Our ref: WA/2020/127698/03-L01
Your ref: 20/00574/F
Date: 30 July 2020

Installation of a standalone solar PV array, associated infrastructure, grid connection, access and landscaping

Land North of Hill Farm, Hill Farm Lane, Duns Tew, OX25 6JJ

| Drawing Title: | Security Fencing |

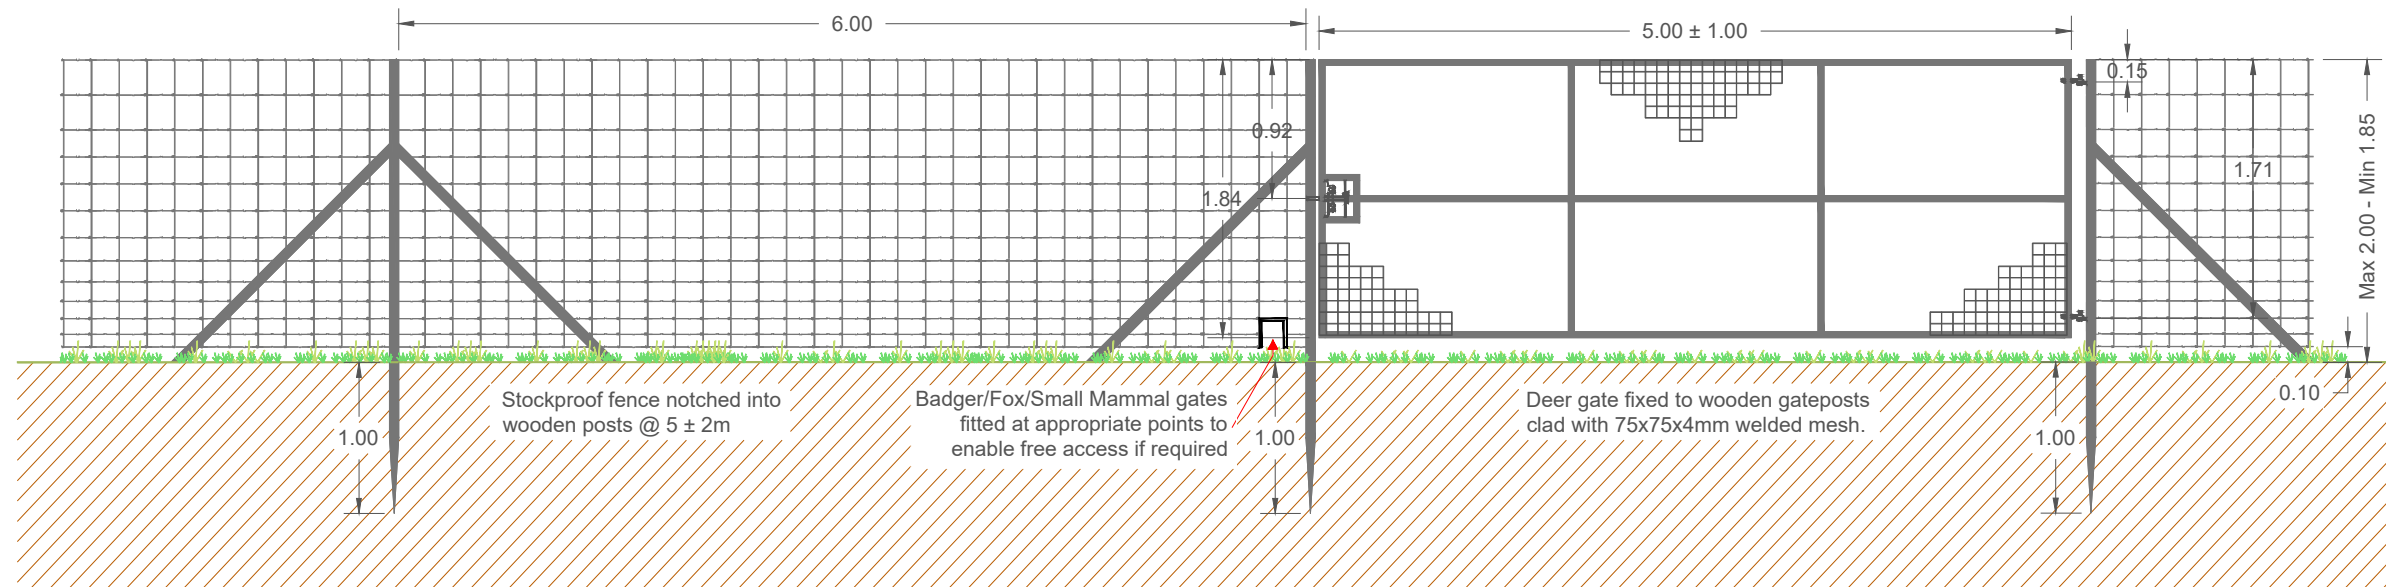
Comparison of drawing no. PV-0446-02 – Site Layout Plan with JFLOW shows that the fencing will be located within Flood Zone 3. We require the fencing to be moved outside of Flood Zone 3 as it can have a significant impact on the flow and storage of flood water, especially if constructed across a flood flow route. If stock control is required a post and rail type fencing is recommended and appropriate in Flood zone 2. This will also allow the functional flood plain (flood zone 3) to become a natural biodiversity corridor.

- All built development must be located within Flood Zone 1
- The solar structures shall be designed to be open to flood water
